MEMORANDUM TO: Lyndsey Fedak, Project Engineer
BLUELINE

REFERENCE: Preliminary Tree Retention Plan, Trees 2 & 25

SITE ADDRESS: 2825 West Mercer Way, Mercer Island WA

DATE: June 19, 2023

PRELIMINARY ROAD PROFILES
2825 W MERCER WAY
PRELIMINARY PLAN
PARCEL #2174502425
CITY OF MERCER ISLAND WASHINGTON

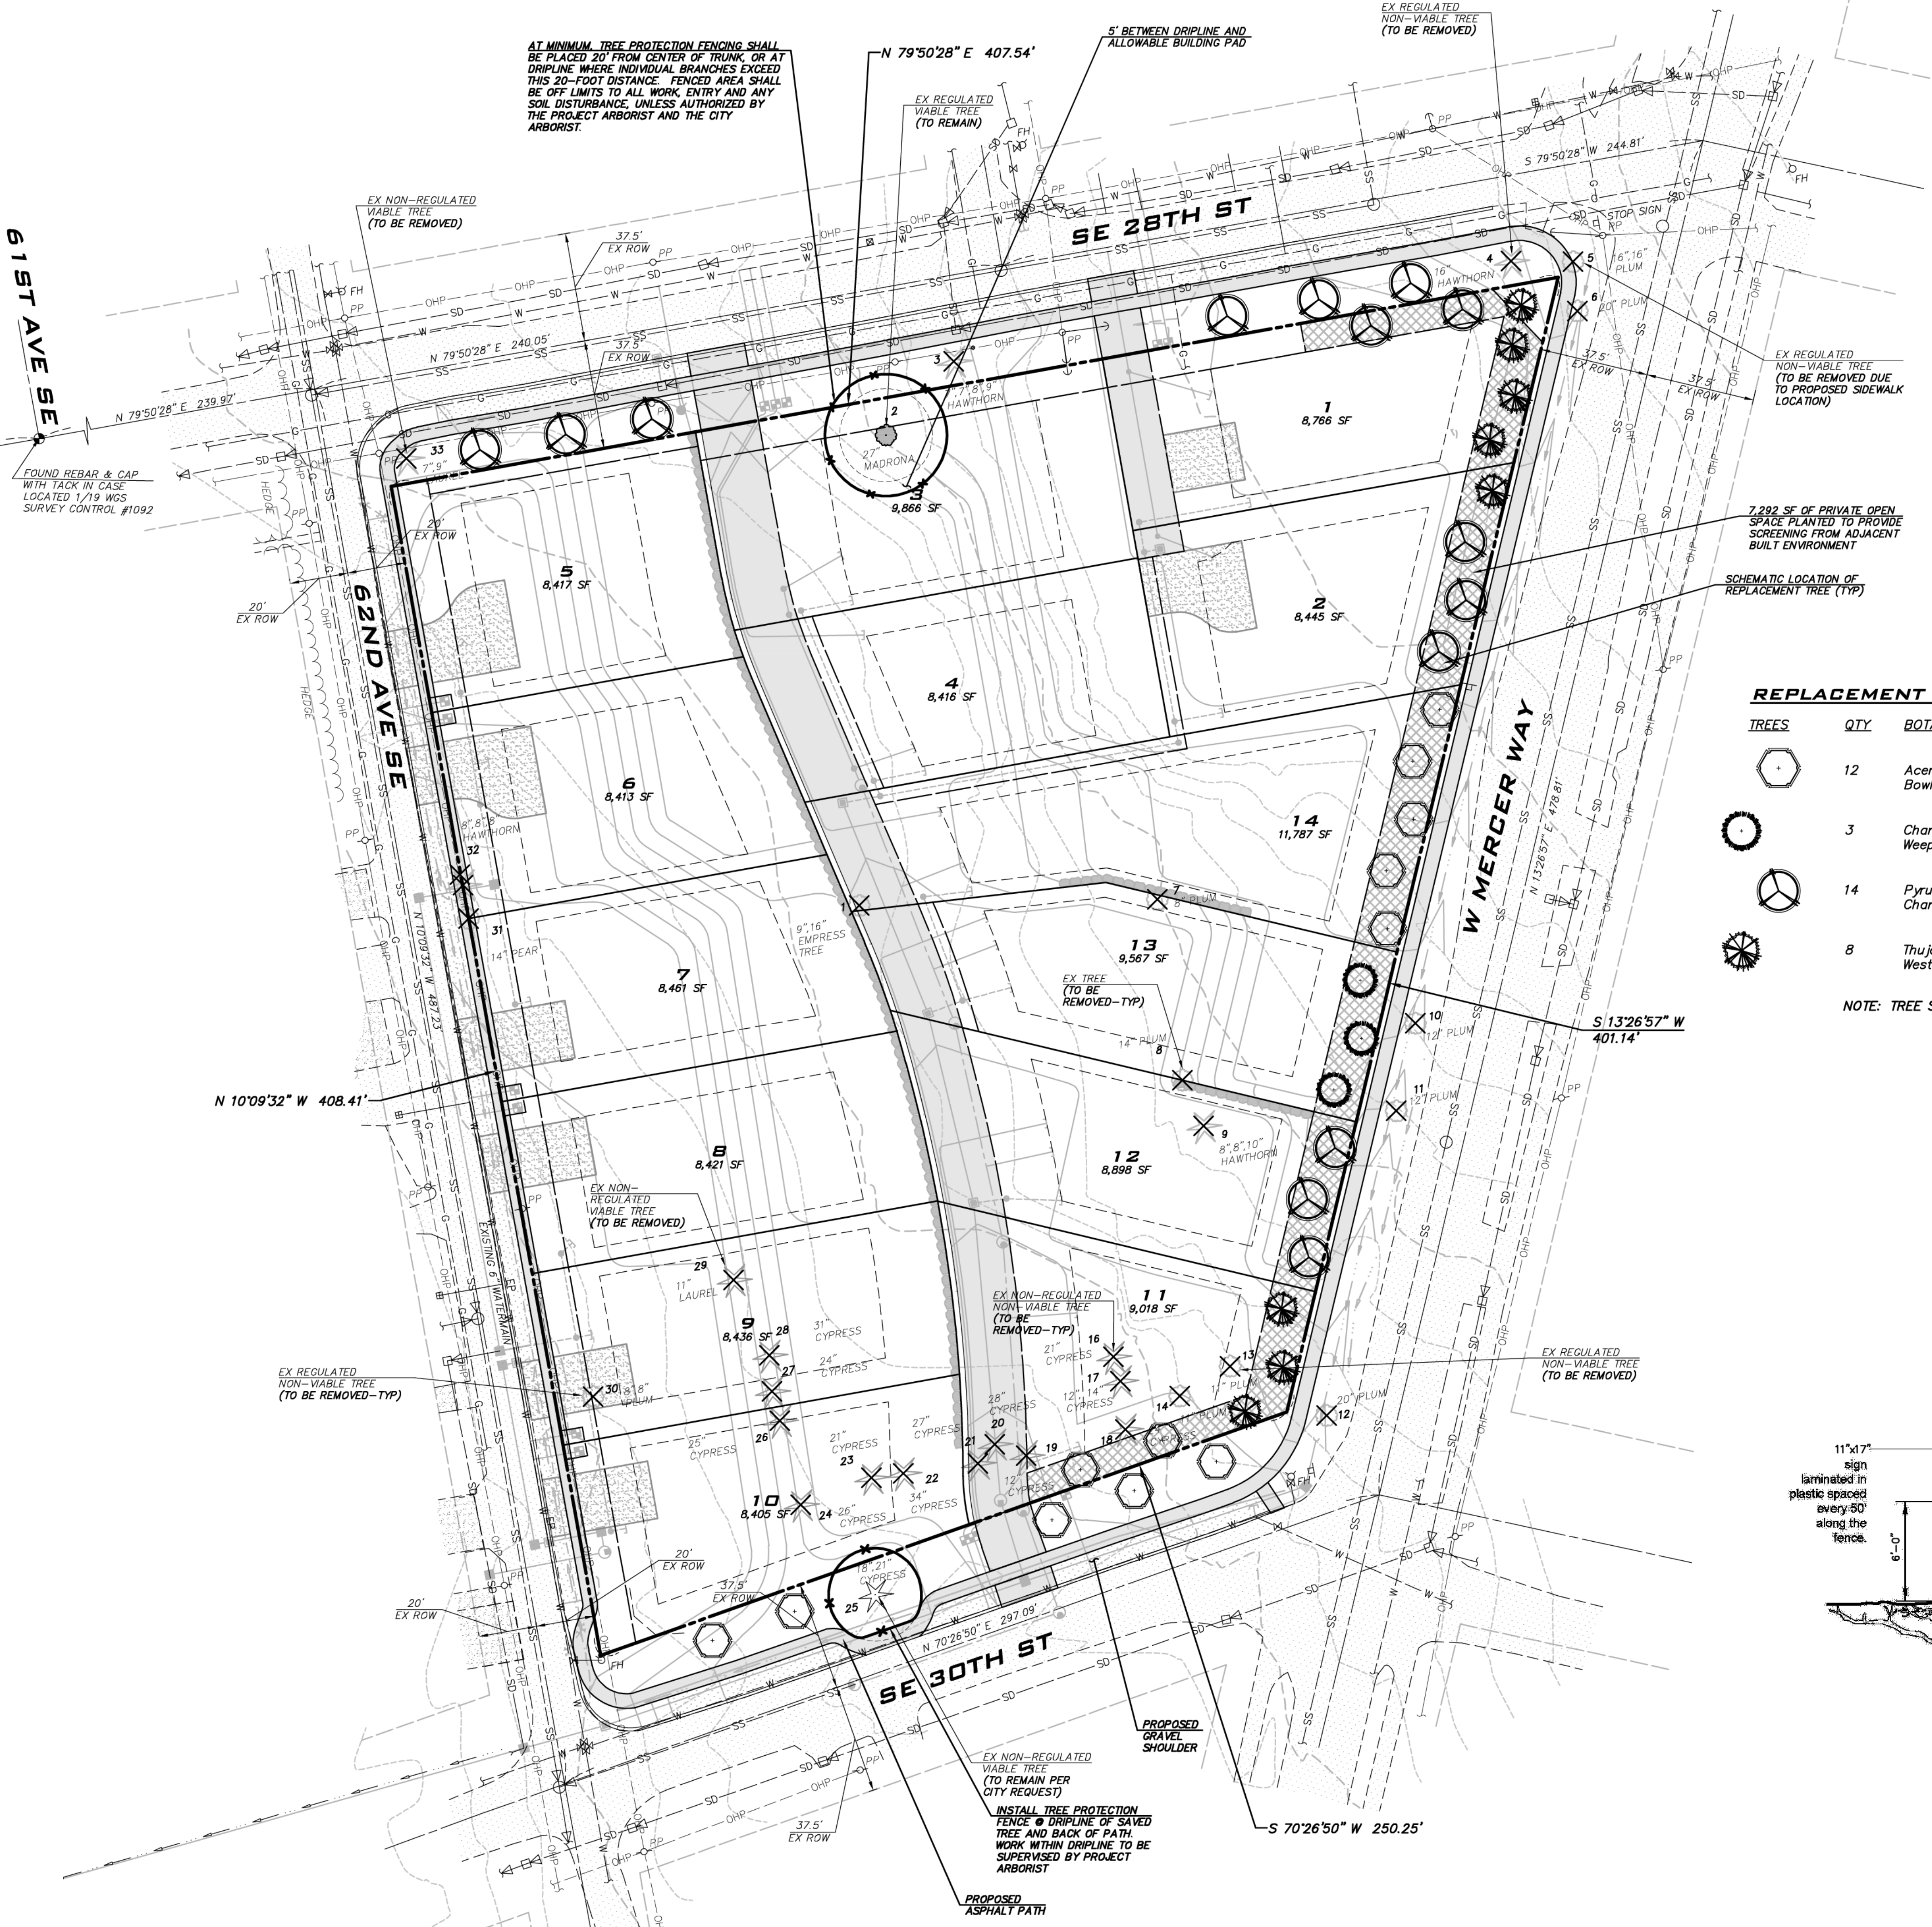
I have reviewed Preliminary Tree Retention and Replacement Plan (TR-01, dated 6/19/2023, see attached), and Preliminary Grading Plan (GP-01).

1. The Tree Protection Zone (TPZ) shall be delineated by the tree protection fencing (TPF) for both retained trees.
2. **TREE 2:** at minimum, TPF shall be placed 20' from center of trunk, or at dripline where individual branches exceed this 20-foot distance.
3. **TREE 25:** place TPF at tree's dripline, except where branches overhang the proposed path south of the tree. Prune low branches as needed to create clearance for proposed path, and place TPF no closer than 12' from center of trunk, as illustrated on TRP.
4. **TPZ shall be off limits** to all work, entry and any soil disturbance, unless authorized by the project arborist and the city arborist.
